Planning Application Reference No.: Application 3/2022/0884

Address of Development: The Duke of York Grindleton

Drawing title  
Proposed Site Plan

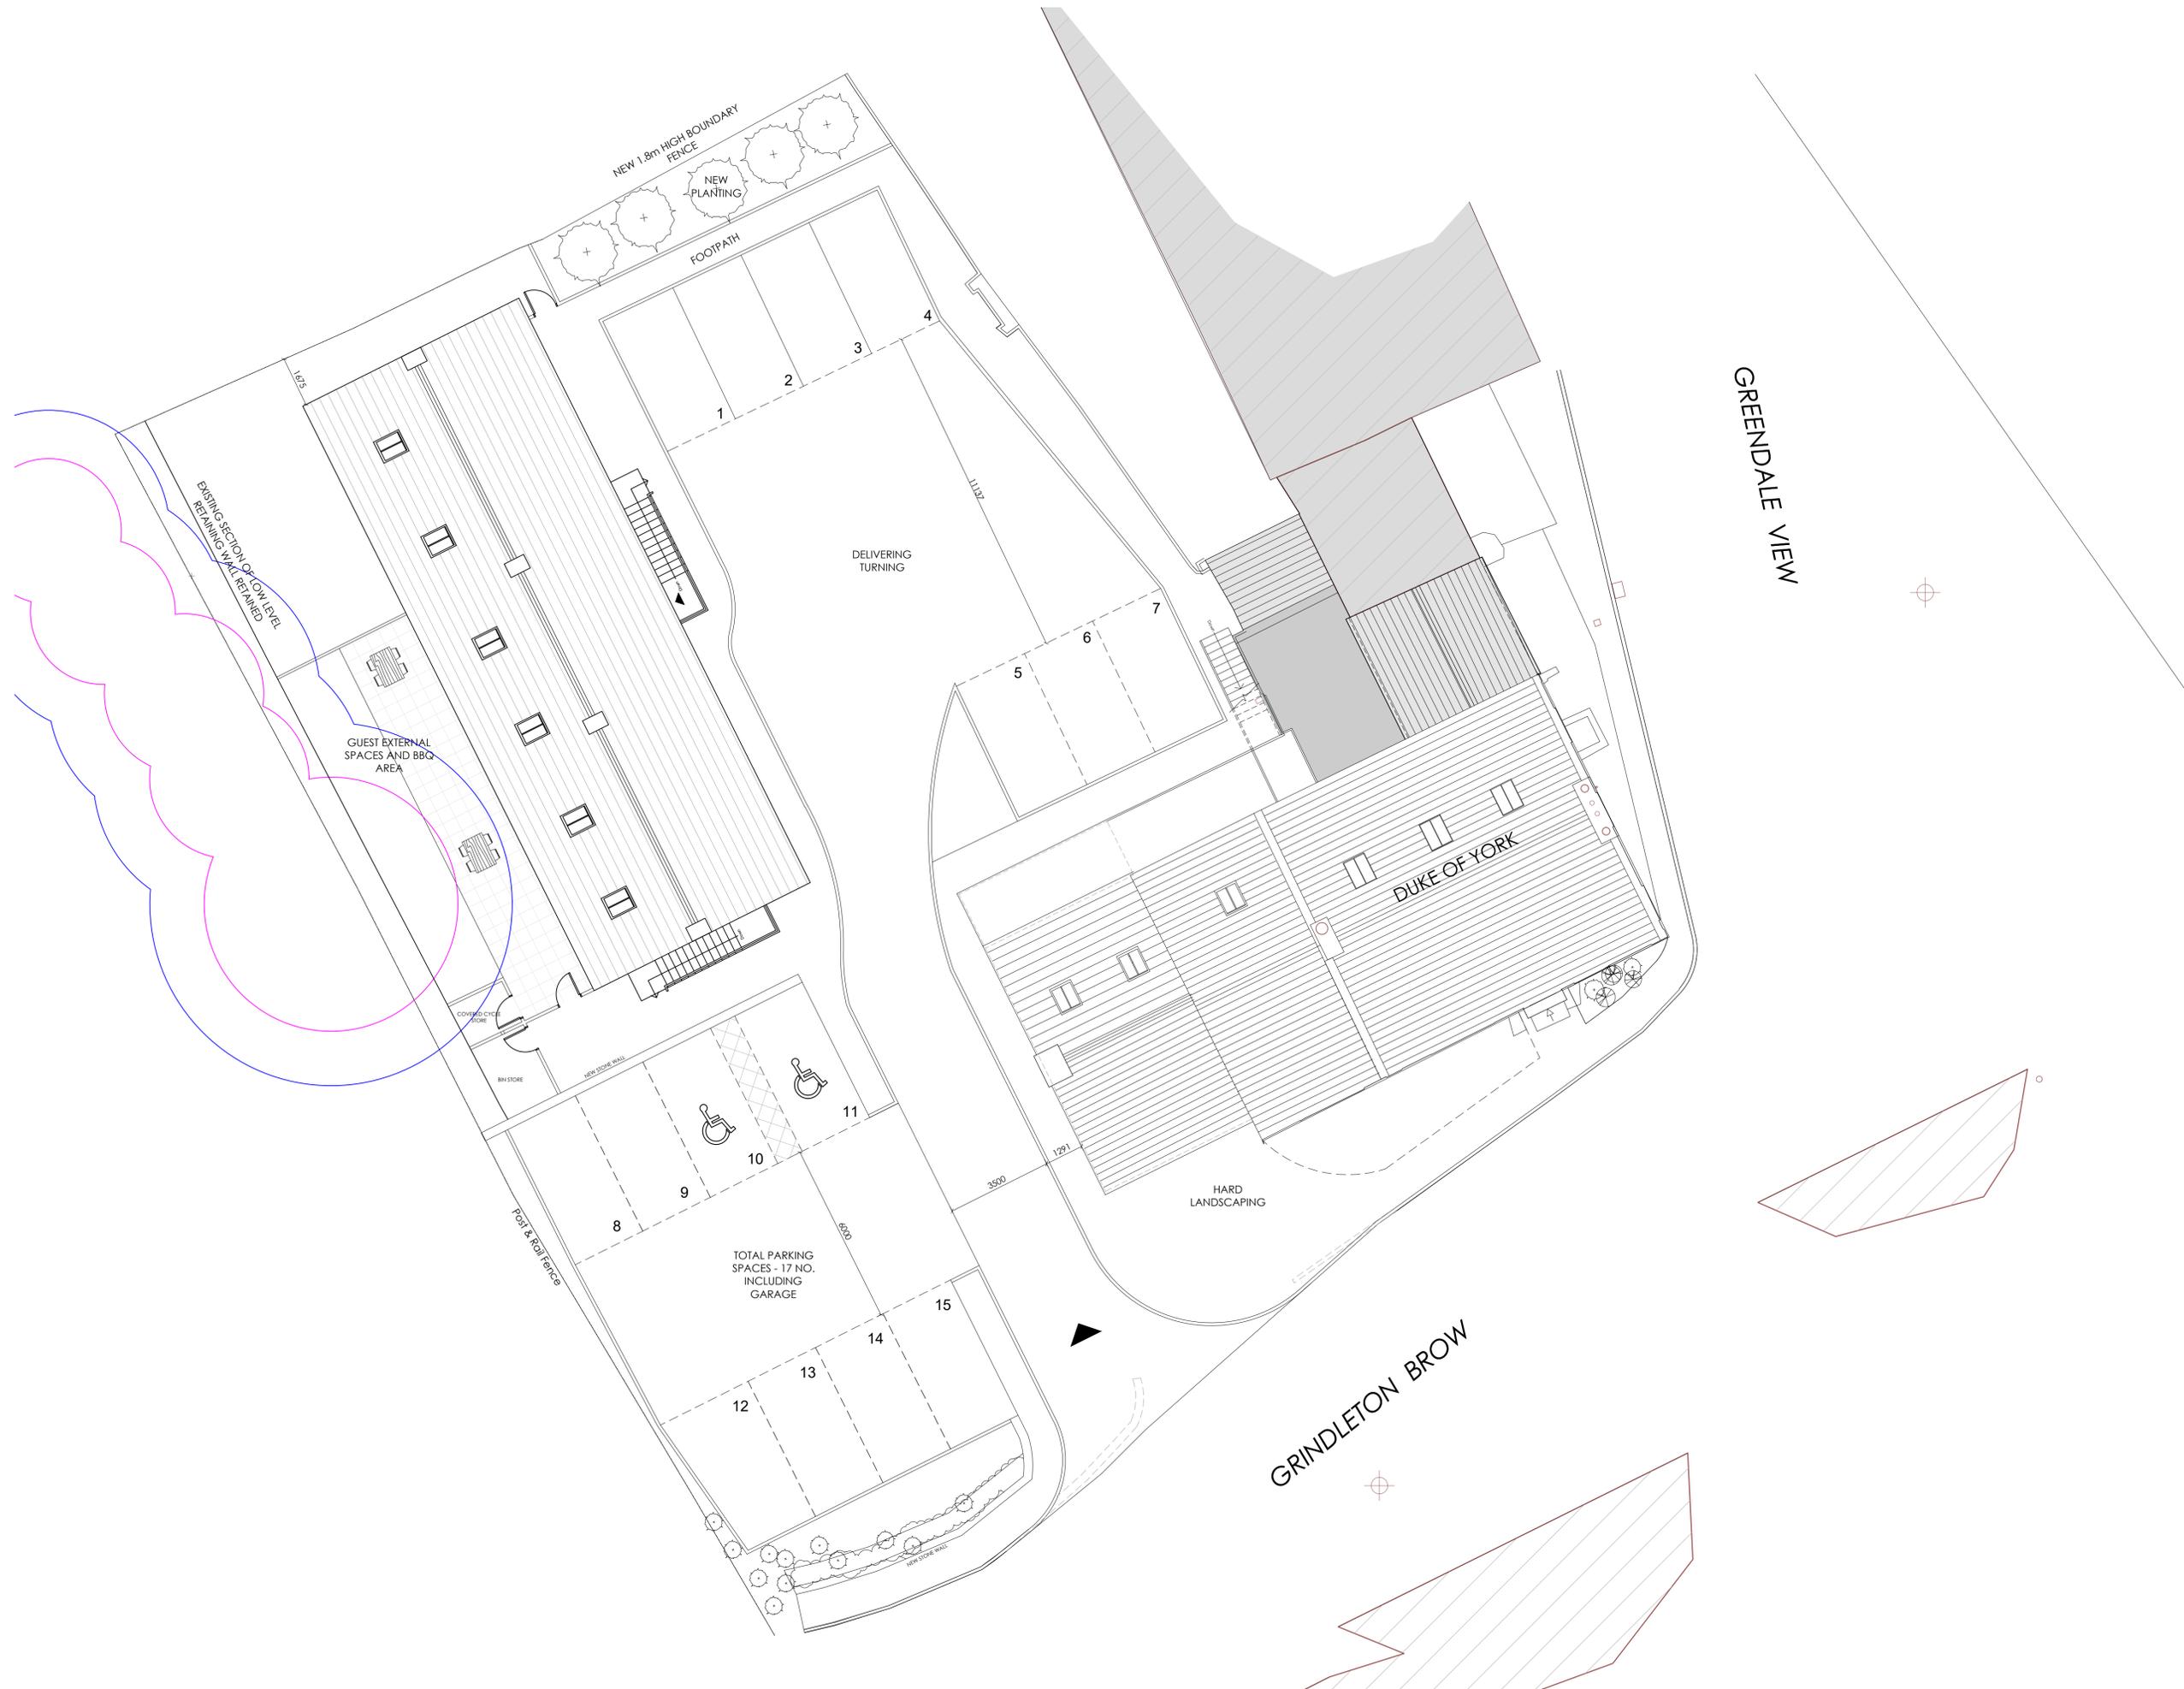
1 I am not sure why the holiday apartments require a double garage.

2 Moving the stairs from the NE elevation of the holiday apartments away from view from the road will enhance the appearance at a focal point of the village.
